Date 03 June 2019

RE: 6/2019/0085/MAJ – Chancellors School, Pine Grove, Brookmans Park, Hatfield, AL9 7BN

Julia Puton
SuDS Officer
Hertfordshire County Council

Drawing Title
 SURFACE WATER DRAINAGE STRATEGY
 EXISTING AND PROPOSED
 IMPERMEABLE AREAS

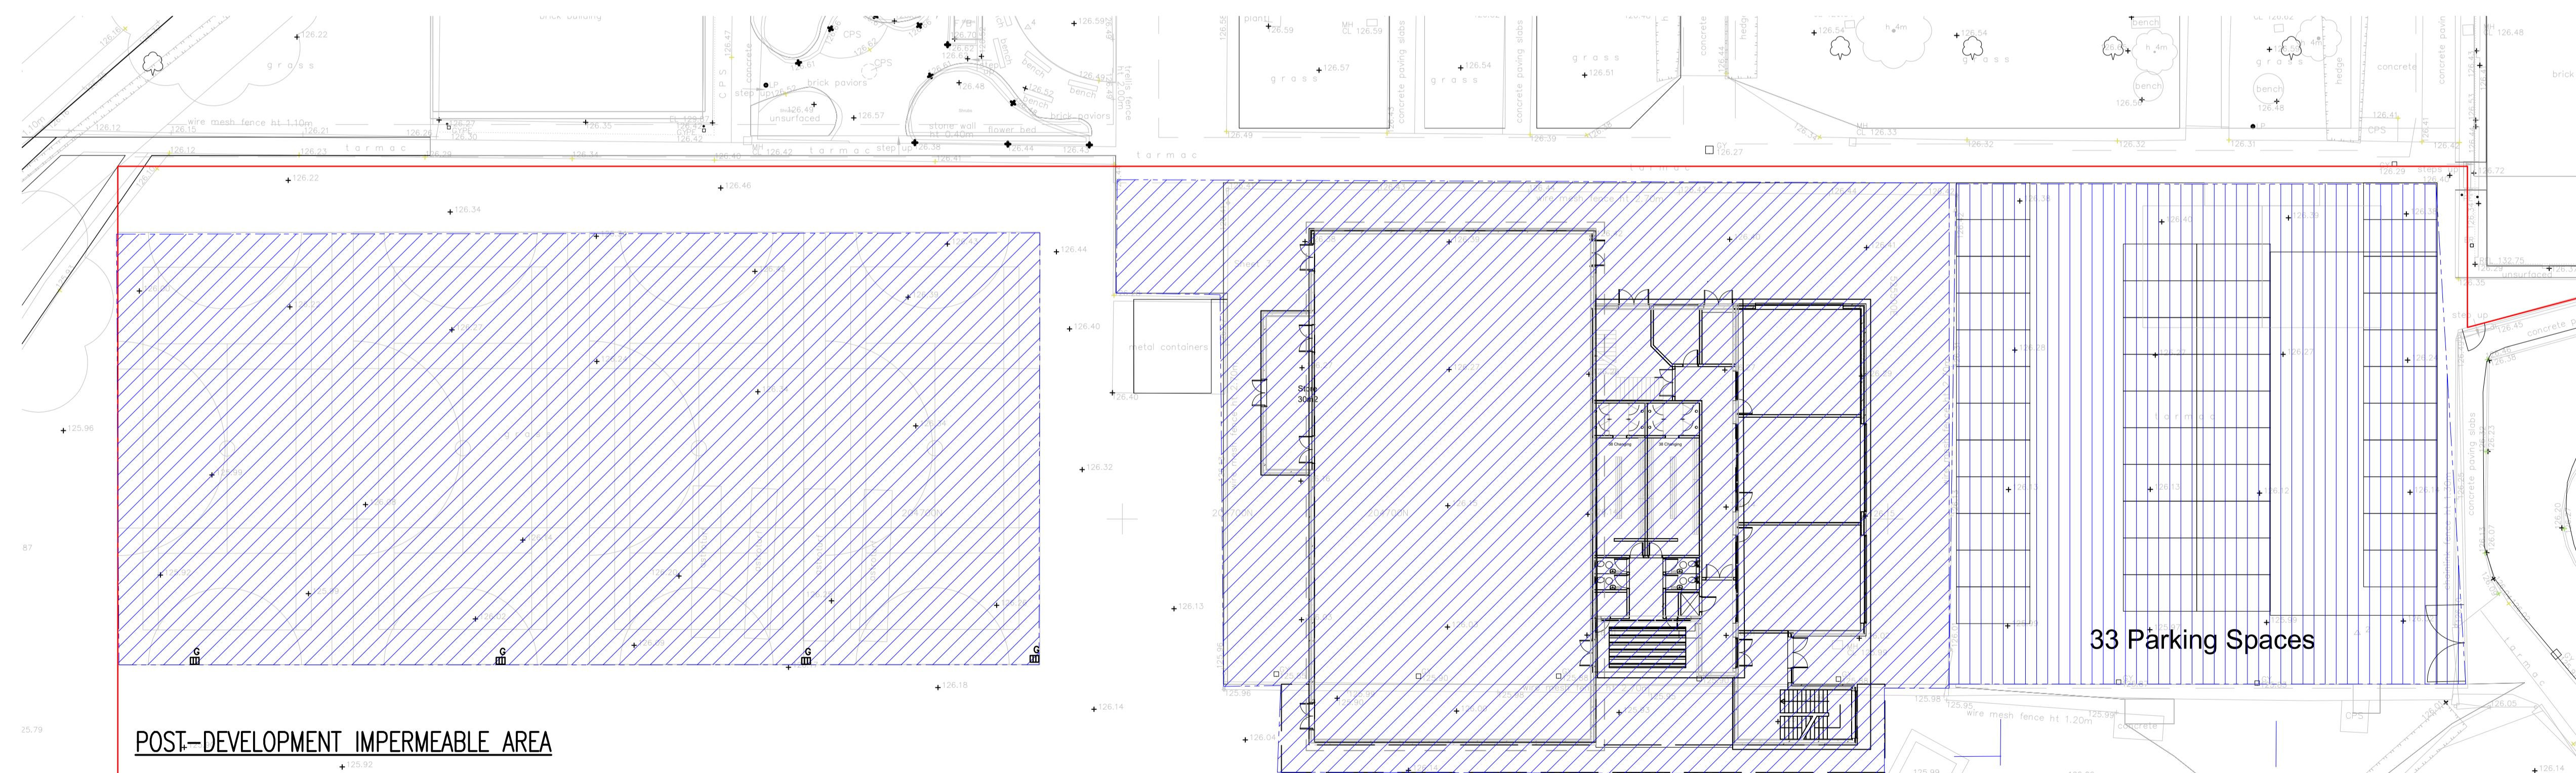
1. As we have stated in our previous letter, we understand that the final surface water discharge from the site is into the existing public surface water sewer.

Therefore, we require confirmation from Thames Water that they are satisfied to receive the proposed discharge at the proposed rates and volumes. As this is for a full planning application we require that this confirmation should be provided prior to the approval of planning permission to ensure that the proposed scheme is feasible. An agreement in principle rather than a formal permission at this stage would be acceptable.

As the applicant discharges surface water from the development site into the public sewer, we would strongly advise the LPA to obtain from the applicant an agreement from Thames Water that they are satisfied to receive the proposed discharge at the proposed rates and volumes.

The applicant can overcome our objection by submitting a surface drainage assessment which covers the deficiencies highlighted above and demonstrates that the development will not increase risk elsewhere and where possible reduces flood risk overall, and gives priority to the use of sustainable drainage methods.
